MP 08_0045

Lake Macquarie Yacht Club Expansion
9 Ada Street
Belmont NSW

**RE: OBJECTION TO PROPOSED REDEVELOPMENT OF LAKE MAQUARIE YACHT CLUB
(08_0045)**

CLIENT: **LAKE MACQUARIE YACHT CLUB** DRAWING: **CAR PARK ALTERATIONS PLAN**

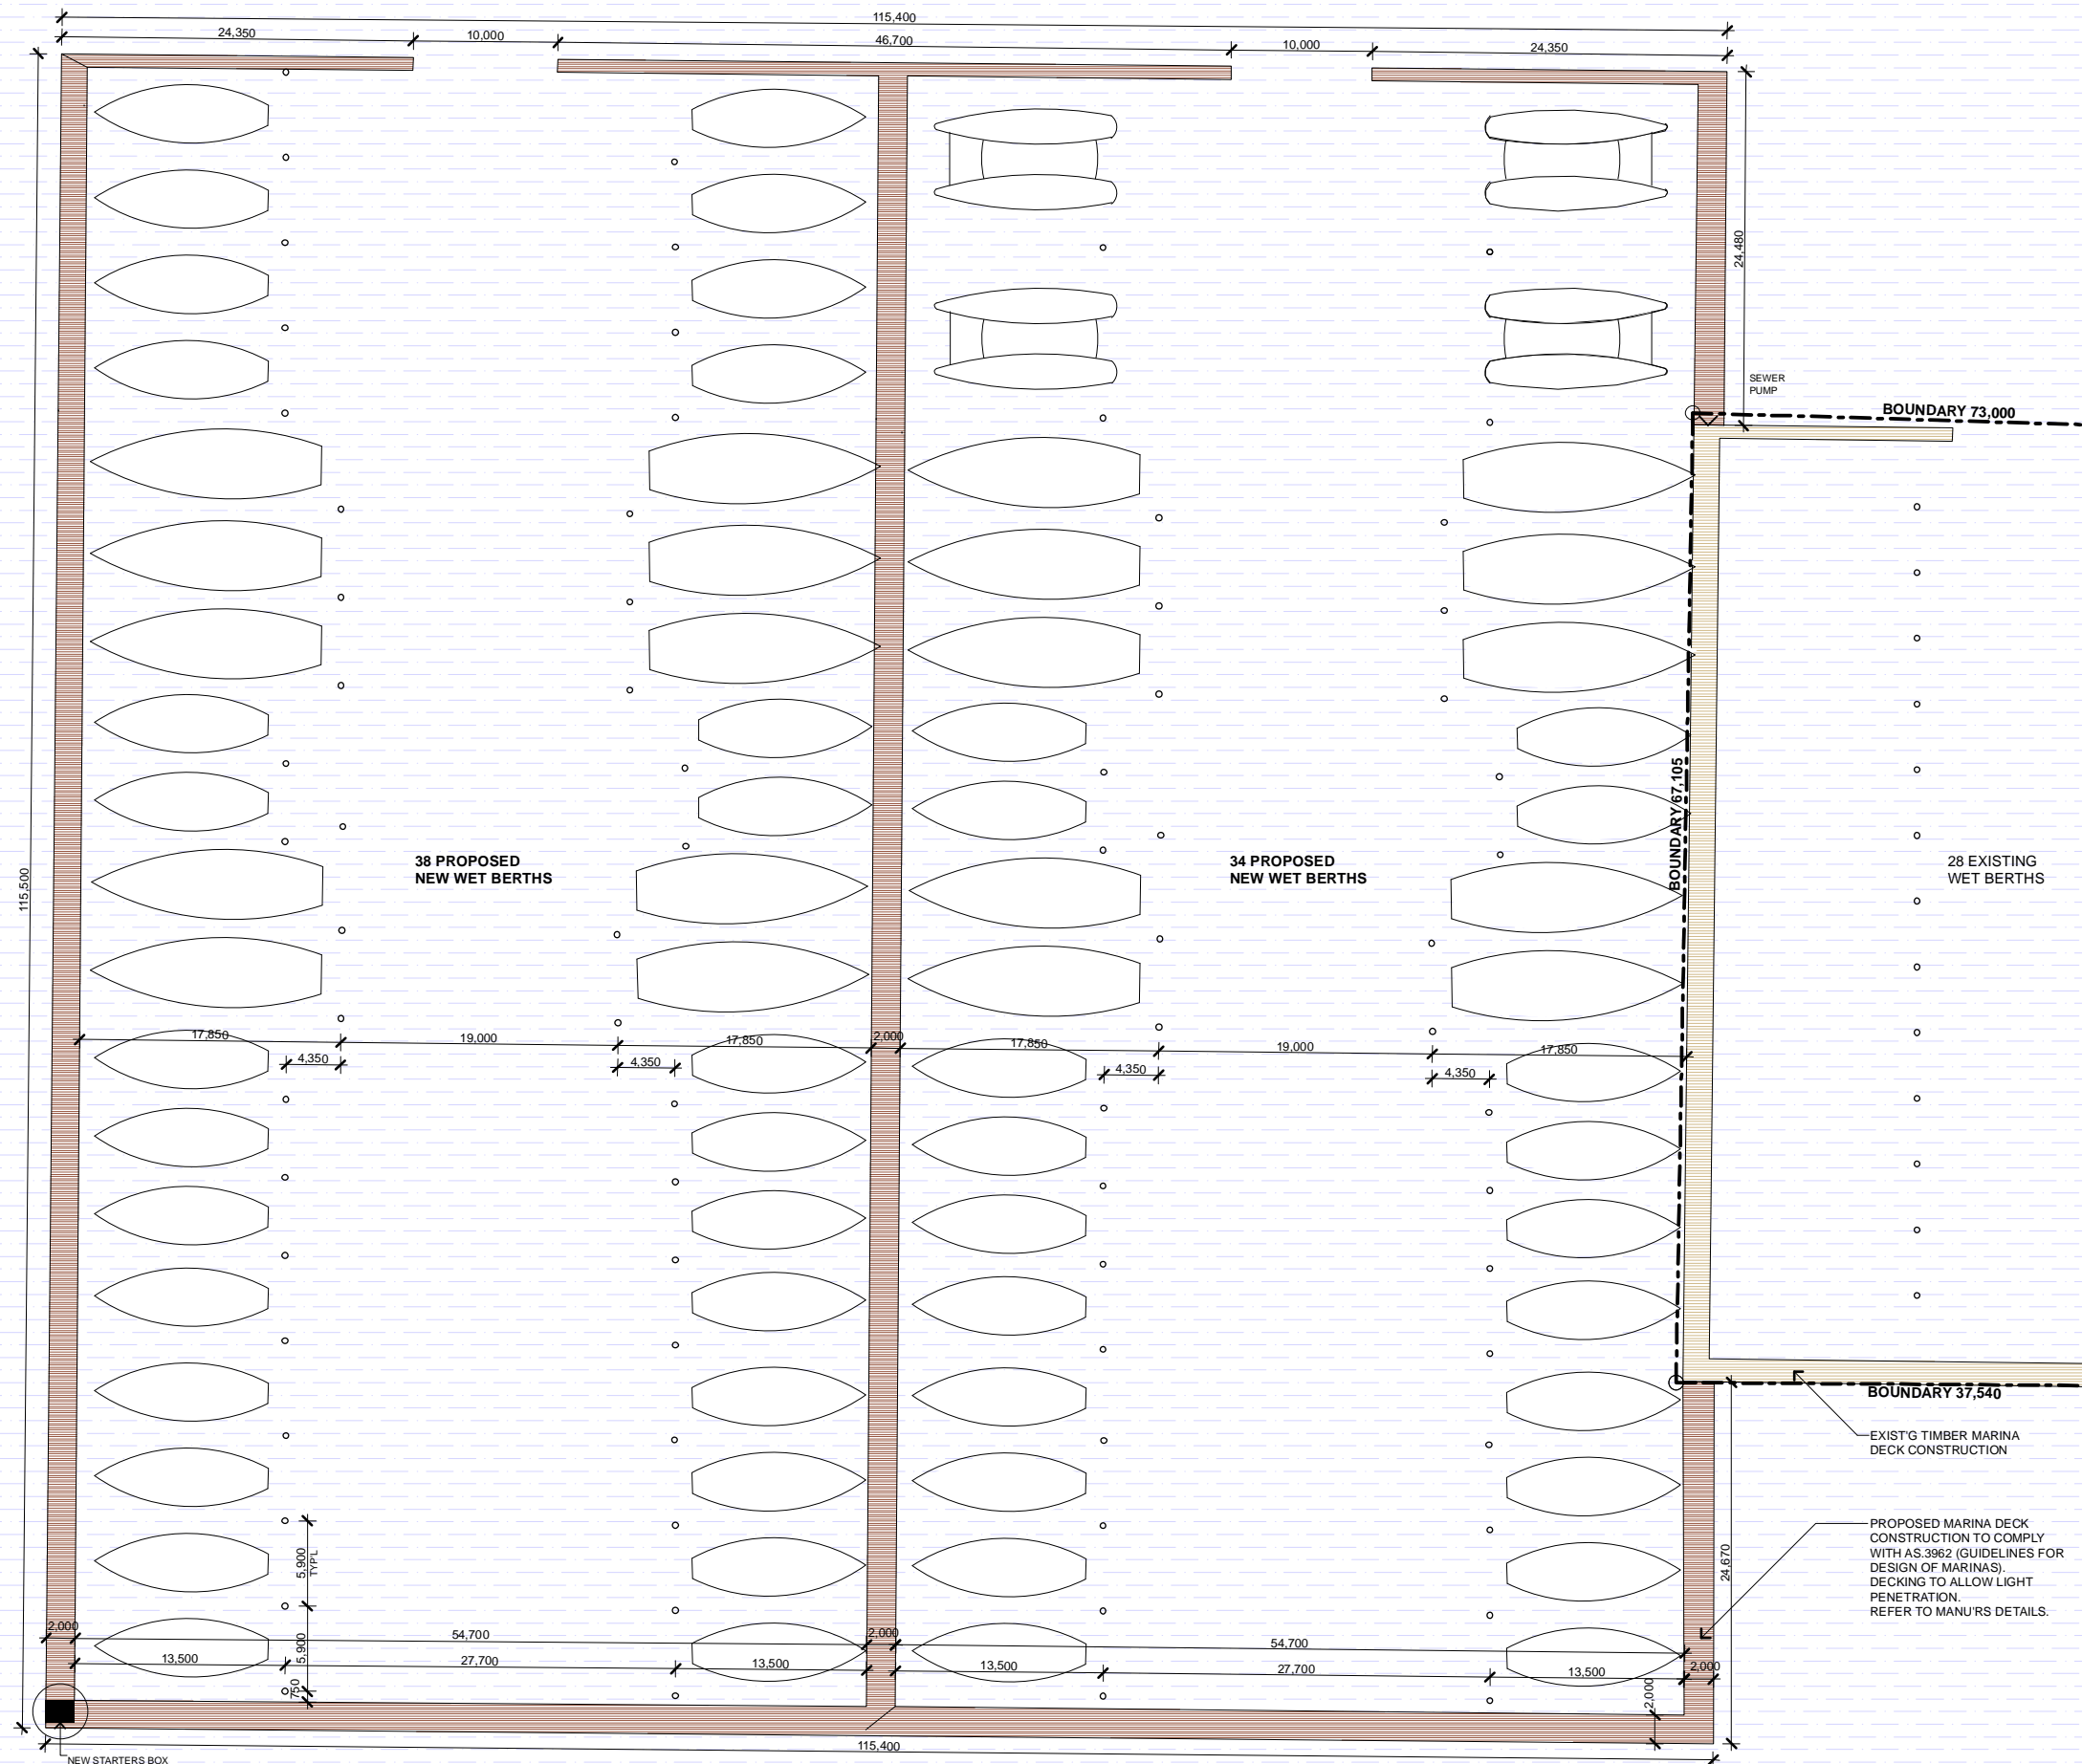
The basis on which the parking assessment has been applied is significantly flawed as it does not account for the large number of swing berths that are leased by private individuals adjacent to the club. The traffic and parking assessment only considers the 8 swing moorings that the club will continue to lease. The aerial photographs provided in the EA show that well in excess of 50 boats use swing mooring adjacent to the club. These have not been taken into account when determining the number of car parks required for the proposed expansion as they are leased by individuals. However, the total number of swing moorings should be included when assessing the demand for parking as these yachts utilise the club and its various facilities requiring space to park. As a consequence, the conclusions drawn in the parking assessment are incorrect and the recommendations outlined in the EA are misleading. If the parking assessment was recalculated based on the true number of berths in the bay (including the swing berths not directly leased by the proponent) it would show there is a significant shortfall in the number of car spaces provided.

Without taking into account the 50+ swing moorings, the parking assessment provided even acknowledges that there will be insufficient parking provided at the redeveloped Yacht Club. To overcome this deficiency it is said that overflow parking can be provided at the TAFE on the opposite of the Pacific Highway towards Belmont shopping centre. It is unrealistic to suggest that parking in such a remote location to the site will work in practice. Human behaviour will no doubt dictate and parking problems will continue to worsen in the already congested local streets as most people will not bother parking at such a distance.

A visit to the club during a race day show the problems currently experienced with parking. It is evident that the parking area does not even satisfy the existing uses. The proposed additional wet berths and significant increase to floor space to allow for large functions will only exacerbate parking problems. The close proximity of the Gunya Hotel also contributes to parking issues with vehicles competing for street parking during peak weekend and holiday periods.

It is recommended that the number of car parking spaces available be calculated and used to help determine what limit should be placed on the development including a an appropriate mix of floor space and mooring

CLIENT: LAKE MACQUARIE YACHT CLUB  
DRAWING: MARINA EXTENSIONS PLAN

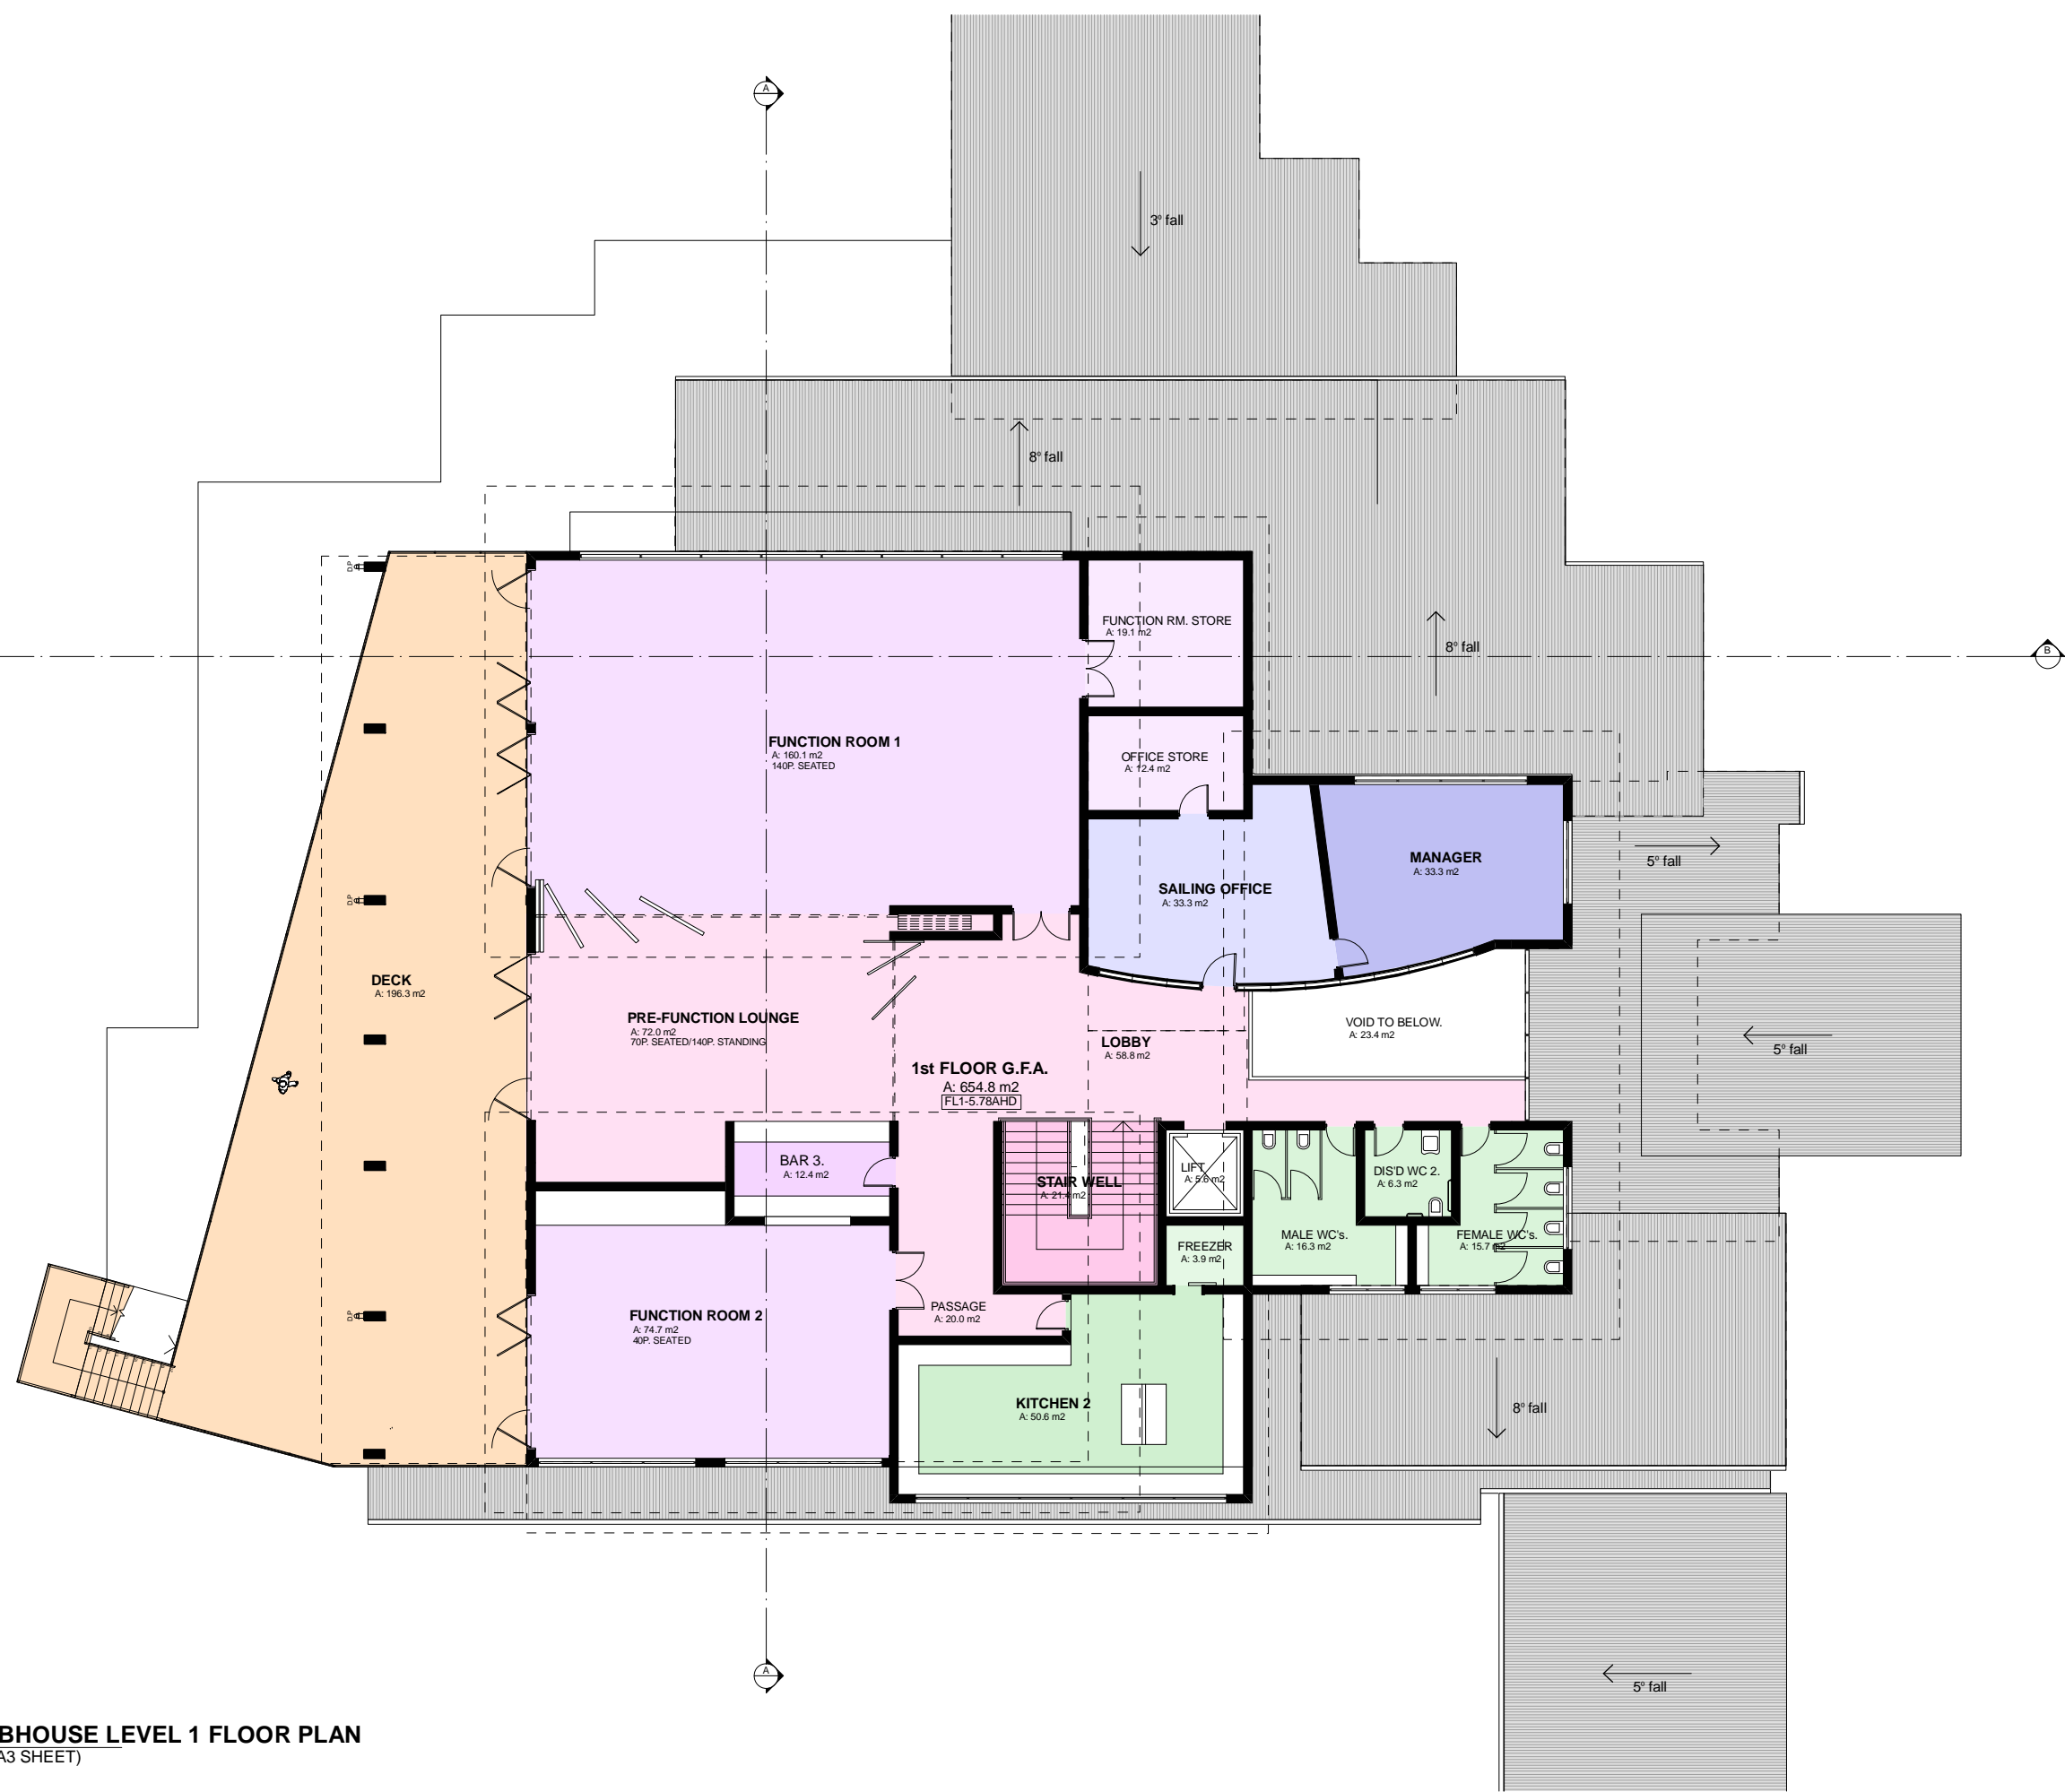
The Club Expansion Proposal intends to extend the marina to jut into the Bay to a distance of some 400 metres with the new section consuming an area of over two football fields. This is a considerable takeover of public lake area which would never get to first base in Sydney Harbour. Not only does it diminish the availability of relatively safe, near-to-shore water for use by the ordinary person, but the expanded Club will preside over the visual aspect of this part of the Bay and restrict the view across the Bay.

The only concession that has been offered by the club to reduce the impact of the proposal is the relinquishment of 4 commercial swing berths currently held by the club. As evidenced by aerial photographs of the site, there are 50+ swing moorings around the existing club. The club acknowledges ownership/responsibility for only 12 of the existing swing moorings. In discussions many years ago with local residents about the proposed redevelopment, it was indicated that the number of swing moorings would be significantly reduced. However, the club now only proposes to reduce the number of swing moorings by 4 which hardly compensates for the proposed 56 additional wet berths.
